9 November 2021

**RE: RESPONSE TO REQUEST FOR ADDITIONAL INFORMATION NO.4 – MOD 14 TO MP_10_0137
HUNTLEE NEW TOWN, BRANXTON**

This letter has been prepared by Ethos Urban on behalf of Huntlee Pty Ltd in response to the request for additional information (RFI) from the Department of Planning, Industry and Environment (DPIE) received 10 June 2021 and 17 September 2021, as well as comments from the Biodiversity and Conservation Division received 18 May 2021, in relation to Modification 14 to MP_10_0137 to modify Stage 1 Project Approval for Huntlee New Town (the site). This letter represents a response to the recent RFI received for this modification. It must be noted that Huntlee currently have approval to develop this part of the site, and that the proposed modification looks to create a more efficient and appropriate subdivision layout.

Figure 1 – Overlay of development footprint within the wider Black Creek Catchment.

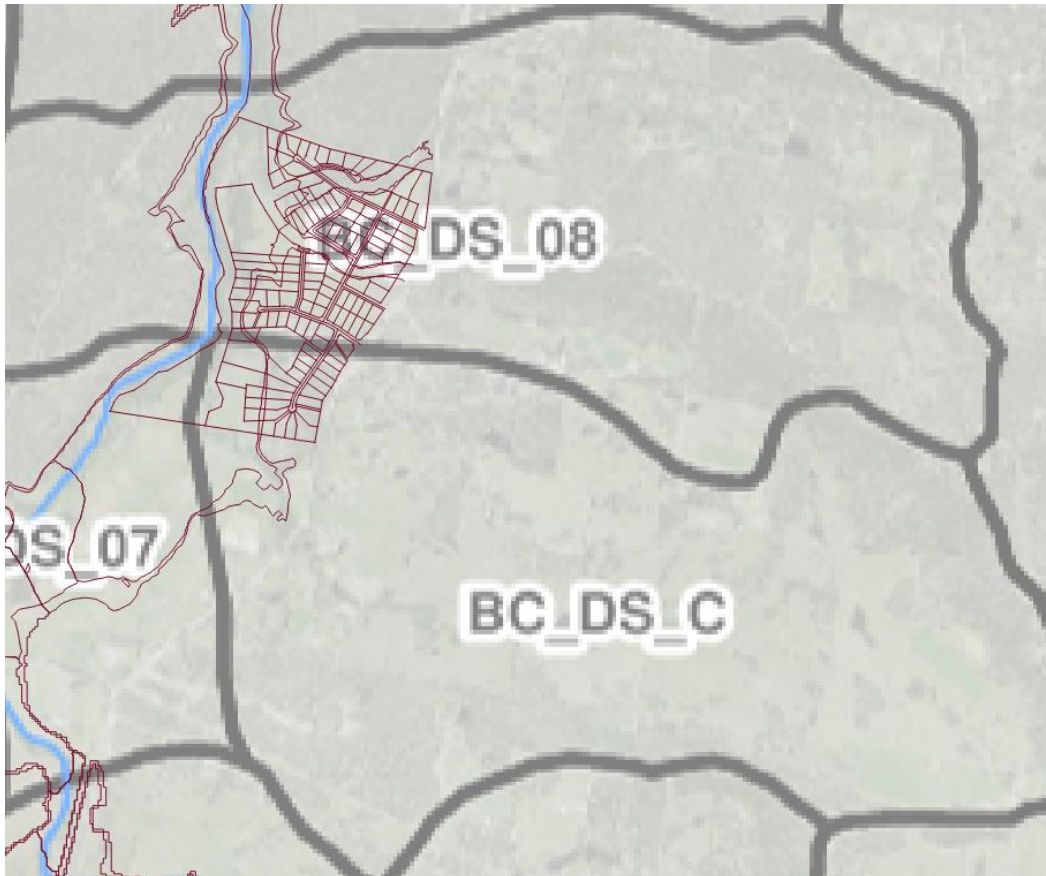
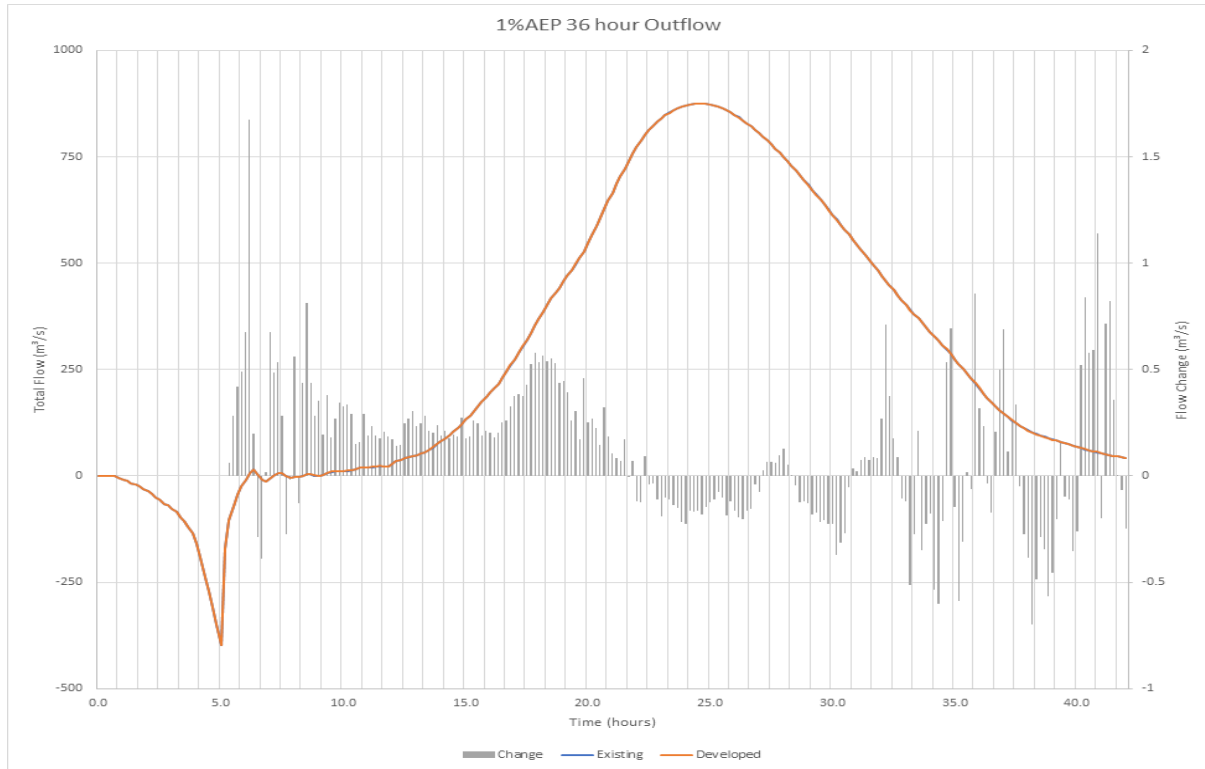
2. On-site stormwater detention will be removed without justification	
The proponent has not justified the removal of on-site detention from its Stormwater Management Strategy. As outlined in point 1, it appears that flood flows have been underestimated and incorrect roughness values have been adopted, therefore the hydrographs provided in support of the proposed modification are not considered to accurately represent stormwater flows.	Attachment B , prepared by Northrop, includes additional assessment undertaken in response to this.
BCD is unable to comment on whether this issue has been adequately addressed until flood modelling is revised as noted in point 1. It is noted that management of erosive discharge to	The Black Creek WBNM was updated by Northrop to reflect an increased impervious fraction across the development and the critical 1% AEP event was run in the TUFLOW model. Even so and given this, it was found that there was a small decrease in peak flow in the WBNM was observed and overall negligible change in the TUFLOW model.

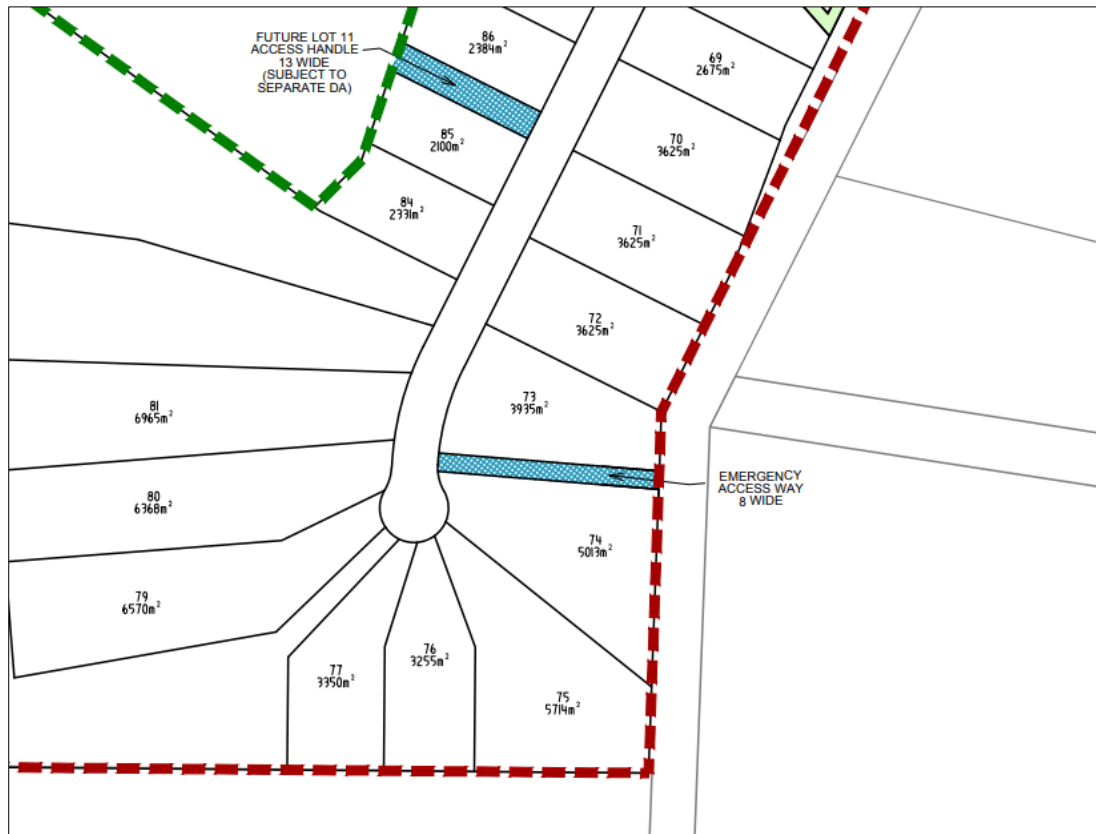
Submission	Applicant Response
DPIE Comments 10 June 2021	
confirmation from an accredited Bushfire Consultant that the emergency access to the south meets the requirements of Table 5.3b of Planning for Bushfire Protection 2019.	Refer to Attachment C .
details of the community title scheme and how the riparian corridor and drainage infrastructure will be managed to ensure appropriate maintenance.	Consent Condition C17 addresses this in that management plans will be prepared in accordance with C17 and incorporated into the Community Title Scheme which will be developed by Huntlee and be informed through a Management Statement which will include the relevant maintenance provisions applicable to the community land. . This will be developed prior to the issue of a Subdivision Certificate. Costs to cover the required level of maintenance of the riparian corridors on community land will be part of the community title fees payable by all lots, as such ensuring that these works will be funded in perpetuity.
